**Our ref:** WA/2011/110603/01-L01  
**Your ref:** 11/01494/OUT  
**Date:** 03 November 2011

**OUTLINE - REDEVELOPMENT OF FORMER MOD SITES. SITE C PLOUGHLEY ROAD & SITES D & E AMBROSDEN ROAD, MOD BICESTER**

We have assessed the following drainage documents:

BIC/OPA/DOC/15 - Graven Hill  
BIC/OPA/DOC/17 - Site C

Figure 34
Graven Hill
Sustainable Urban Drainage Strategy
(SUDs)

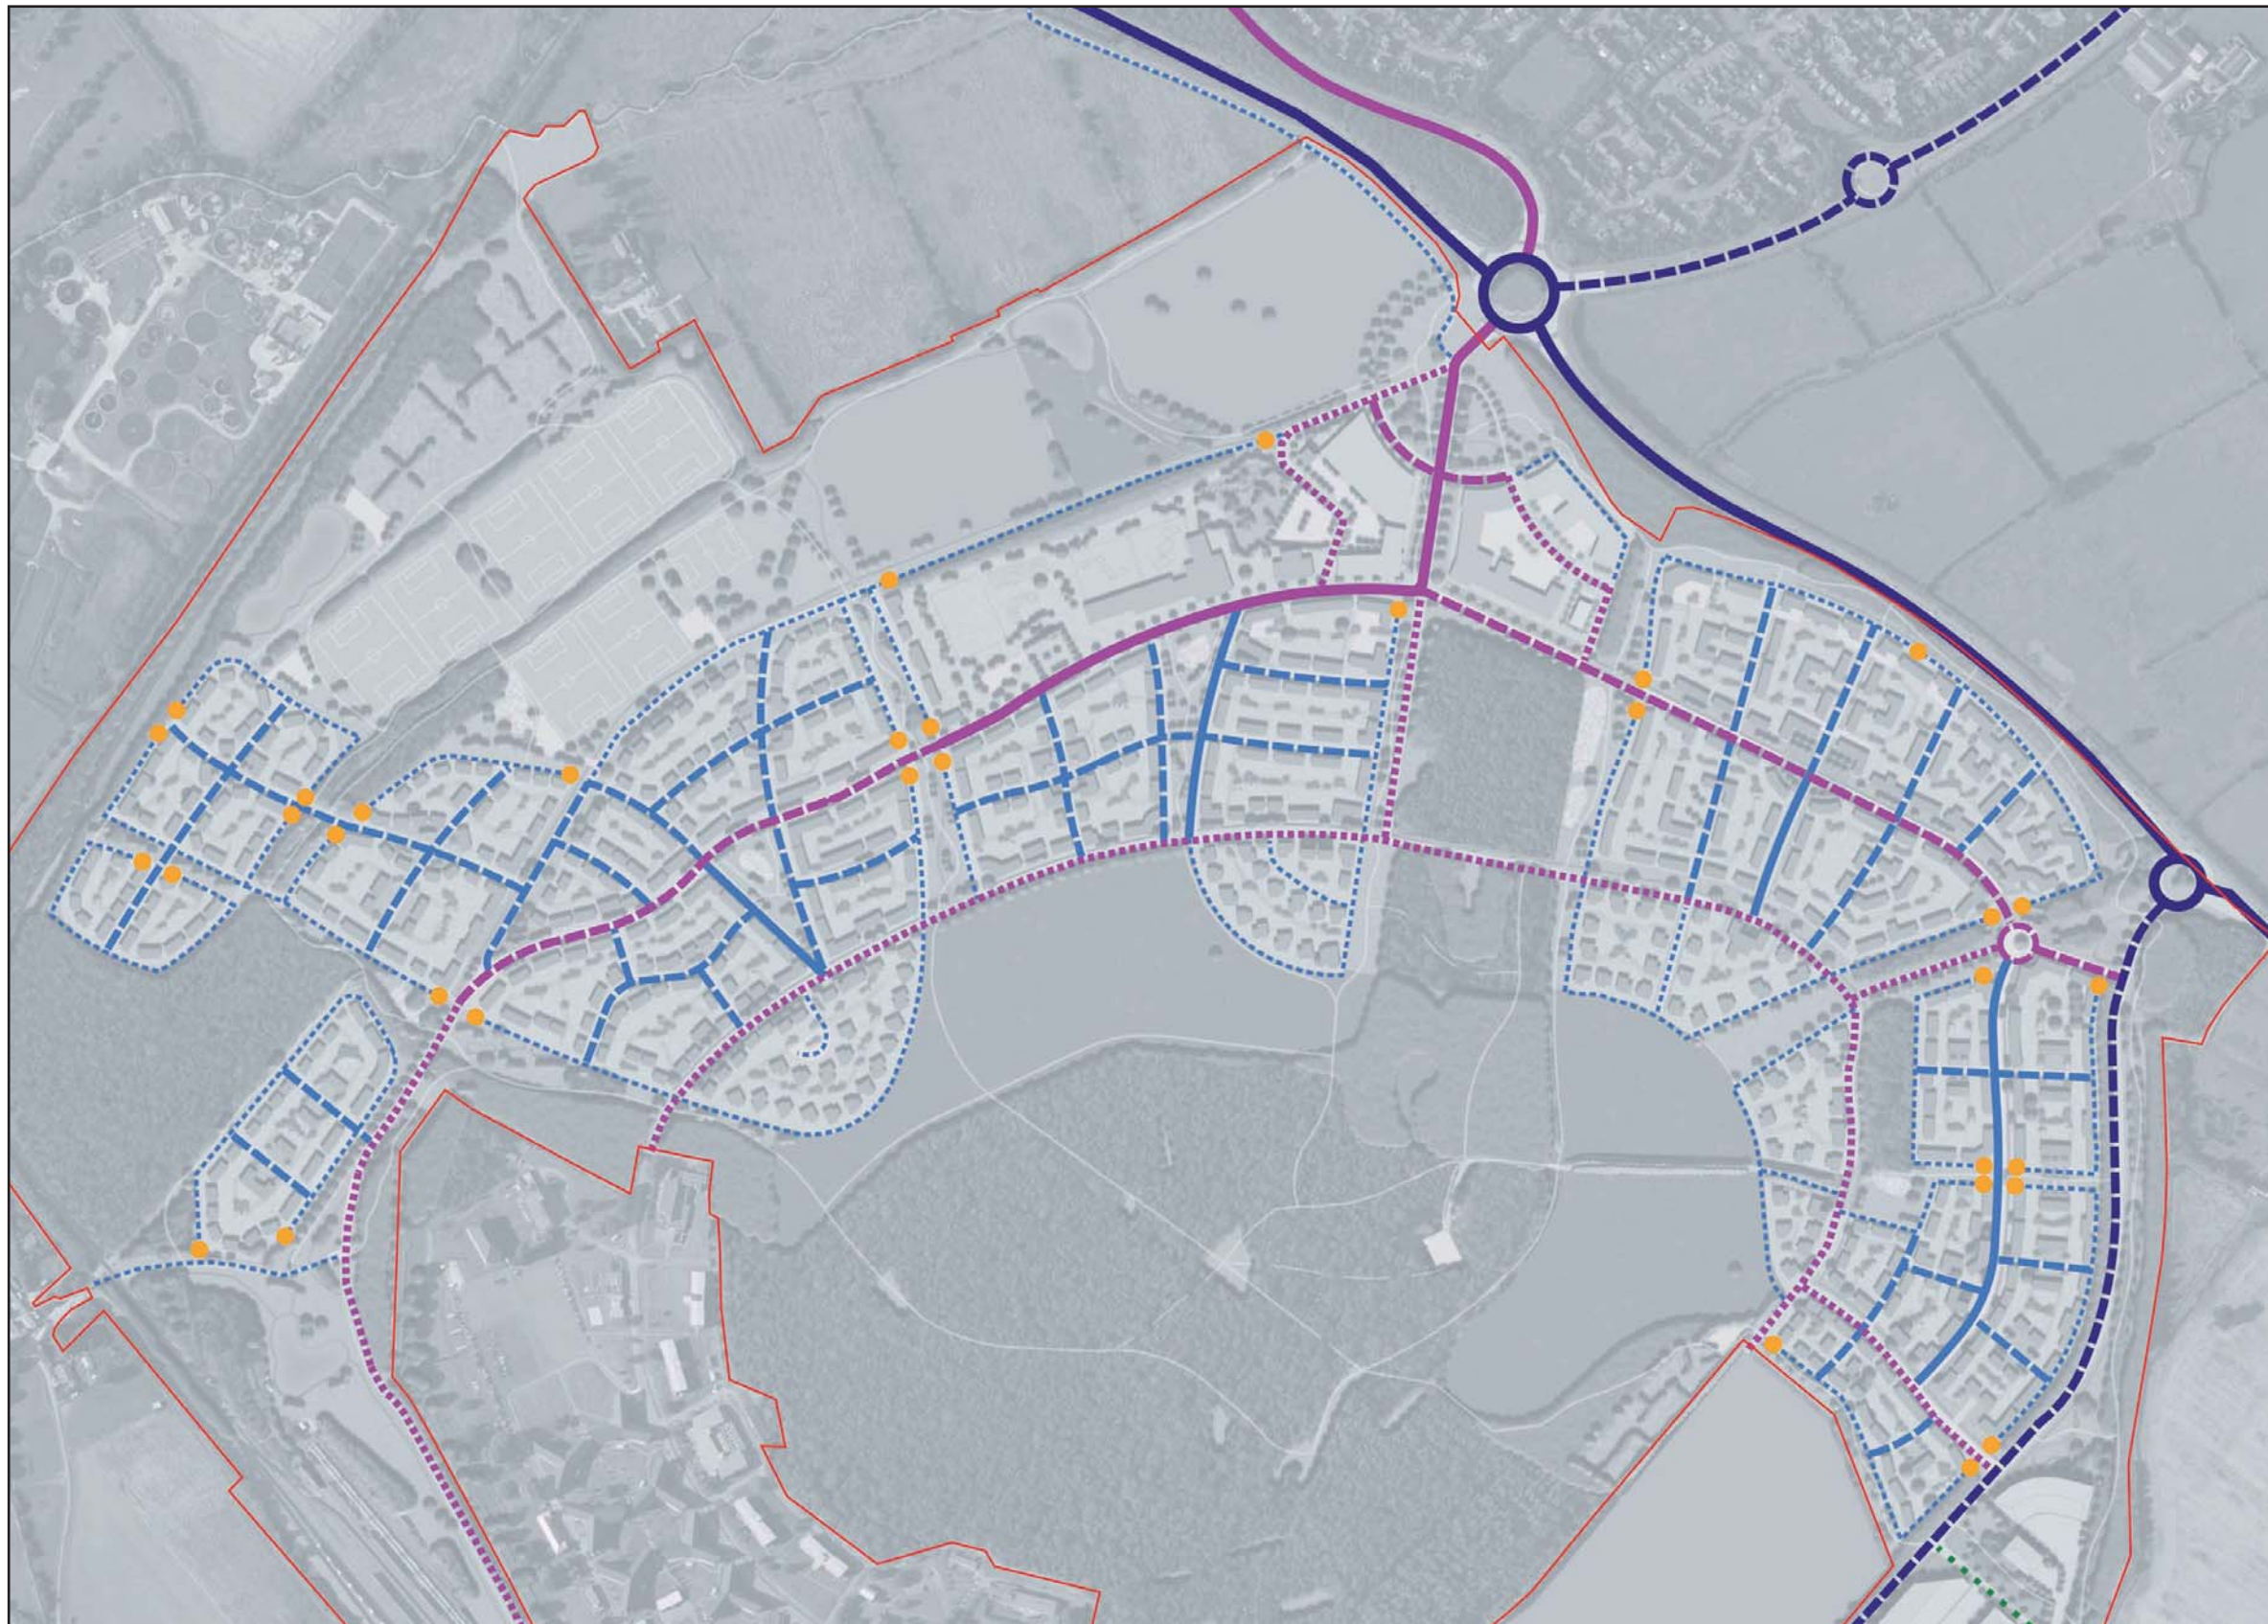
As the design progresses, the use of pipes should be minimised in favour of open ditches and swales.

As a point of note, Section 4.2.3 of the Site C drainage strategy states that a minimum of two stages of the SuDS management train should be employed on the site. However, the 'High Level SuDS Assessment' enclosed in Appendix C of the strategy concludes that at least 3 stages of the train should be used.

Development shall not begin until a surface water drainage scheme for the site, based on sustainable drainage principles and an assessment of the hydrological and hydro geological context of the development, has been submitted to and approved in writing by the local planning authority. The scheme shall subsequently be implemented in accordance with the approved details before the development is completed.
